Bylong Coal Project – Response to Submissions – OEH Comments

Attachment A: OEH Review – Response to Submissions, Biodiversity Assessment Report and Biodiversity Offset Strategy

PROPOSED BYLONG COAL PROJECT – RESPONSE TO SUBMISSIONS REPORT

ATTACHMENT 1 – EPA COMMENT BY LONG COAL PROJECT RESPONSE TO SUBMISSIONS REPORT (RTS)

Figure 4-6: Offset Area 5 – Land Use

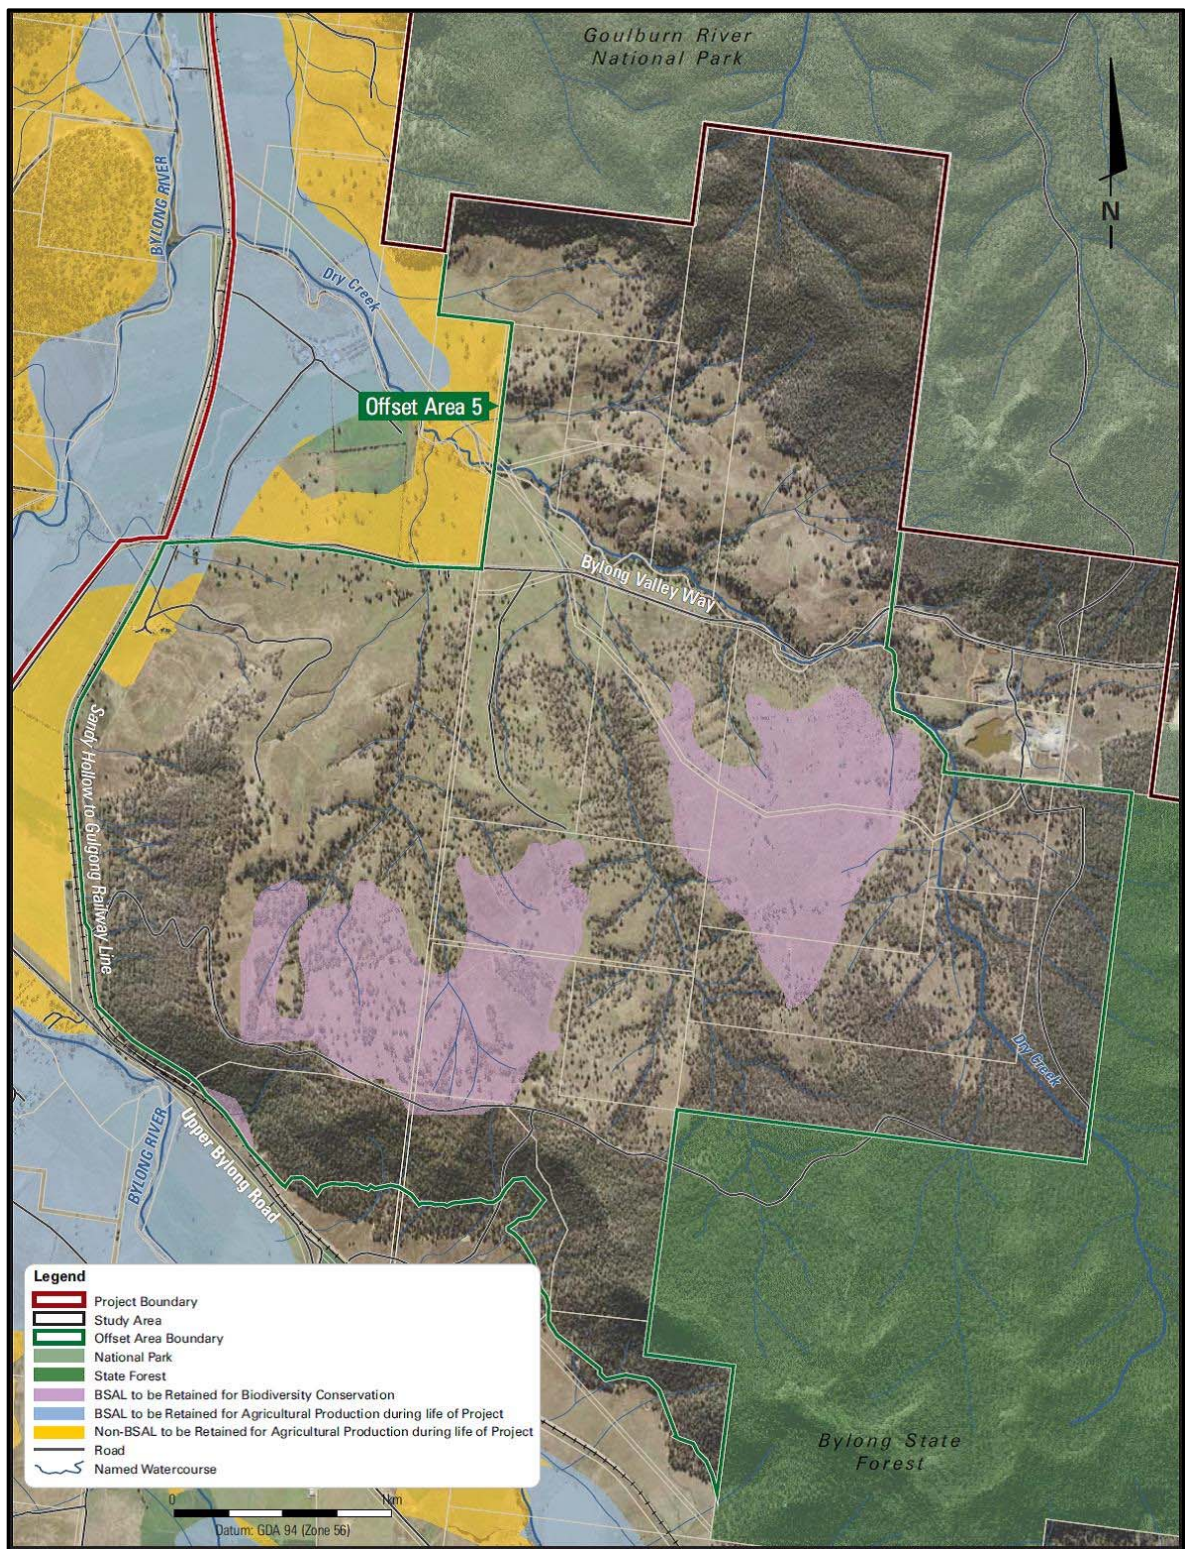
OEH has previously expressed concern regarding the appropriateness of Offset Areas 5 (OA5) as an offset property as the area will be subject to damage from surface cracking and subsidence caused by longwall mining directly under approximately 70 per cent of the proposed offset area. However, for the purposes of this RTS review, OEH is prepared to accept OA5 as part of the indicative BOS presented.

However, as noted in previous correspondence, including OEH's response to the EIS on 6 November 2015, Section 11(1) of the *Threatened Species Conservation (Biodiversity Banking) Regulation 2008* (BioBanking Regulation) indicates that the land in OA5 is not suitable to be designated as a BioBank site as the area will be subject to future impact from underground mining. Therefore, the offsetting

value of OA5 should be assessed after mining-related impacts have ceased, then secured through BioBanking if it delivers the credits required for this offset area. Prior to the cessation of mining impacts on OA5, the *NSW Biodiversity Offsets Policy for Major Projects* (Offsets Policy) indicates that a voluntary planning agreement under s93F of the EP&A Act may be a suitable mechanism to secure the offset. Alternatively a Trust Agreement under the *Nature Conservation Trust Act 2001* may be a suitable mechanism. Further discussion on this matter between KEPCO, DP&E and OEH will be required.

- 2.1. DP&E accept OA5 as an offset option, secured under the Offsets Policy, subject to final FBA assessment after mining impacts have ceased. If mining impacts are greater than predicted, additional offsetting may be required.
- 2.2. KEPCO and DP&E continue to liaise with OEH to resolve a completed BOS including full data as required by the FBA for offset sites.
- 2.3. DP&E ensure that offset areas are secured under the provisions of the Offsets Policy.
